Planning Application Ref: **AW/328/20/T**

Location: **7 Follett Close, Aldwick, PO21 4XH**

Description of works: **4no. silver birch trees (T95, T96, T97 & T98) - reduce height to approx. 20-25m and Crown lift to 4m**

TPO/AW/228/10

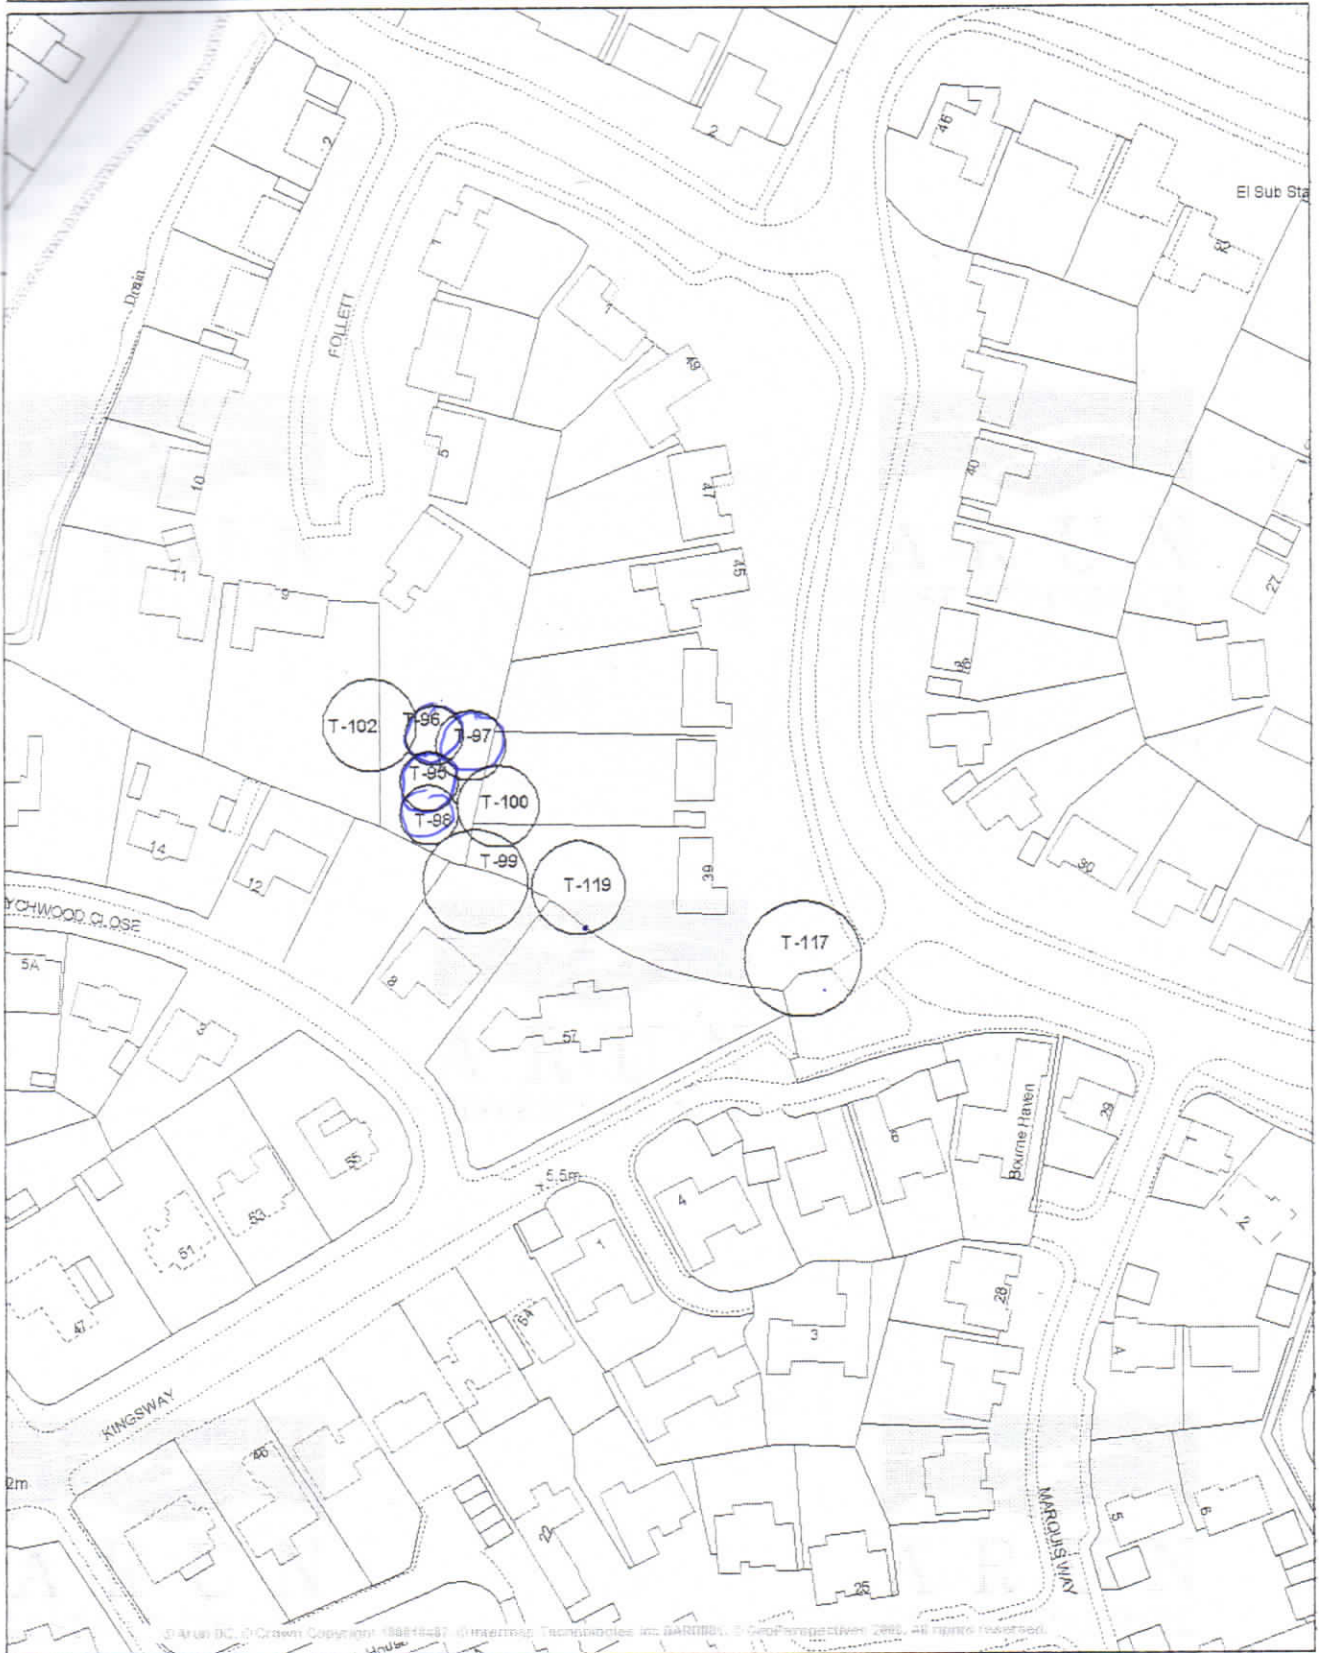
- T97 is the northernmost birch, approximately 16m height with a uniform and unmodified crown. It displays all the mature characteristics of the species and is a fine specimen tree. T96 is also a single-stemmed tree with fine form and slightly apart from the group although less so than T97.

- T95 and T98 are similarly unmodified and important constituents of the group although they are of lesser form and markedly inferior.
- Although a large garden which comfortably accommodates these trees; ground conditions are influenced by heavy shading and damp conditions seem to prevail. It seems reasonable to permit a degree of pruning to improve those conditions although must be focused on selected trees rather than applied to the entire group, if we are to preserve visual amenity as the Tree Preservation Order intended.

- The removal of dead branches is an exception and does not require permission.
- The extent of height reduction proposed is not possible to interpret given the disparity with my own estimation of existing top-height.

- These trees (in particular T97) require careful management that respect their age and vulnerability to environmental changes and disease progression.
- Height reduction proposals cannot be properly interpreted from the measurements provided. That said, I would be comfortable with some reduction pruning on T95 & T98 and I make suggestions for a revision of the work proposal below.
- The removal of low branches to achieve 4m clearance above ground level is not justified on arboricultural grounds and exceeds that which is recommended in the British Standard (BS3998:2010) Tree work – Recommendations. Lesser works would be suitable, and I make suggestions for a revision of the work proposal below.

T95, T96, T97 & T98

- Crown lift (removal/reduction of low branches) to achieve no more than 3metres overhead clearance on all aspects.

T95 & T98 only

- Reduce top-height only to leave a minimum of 12metres above ground level.
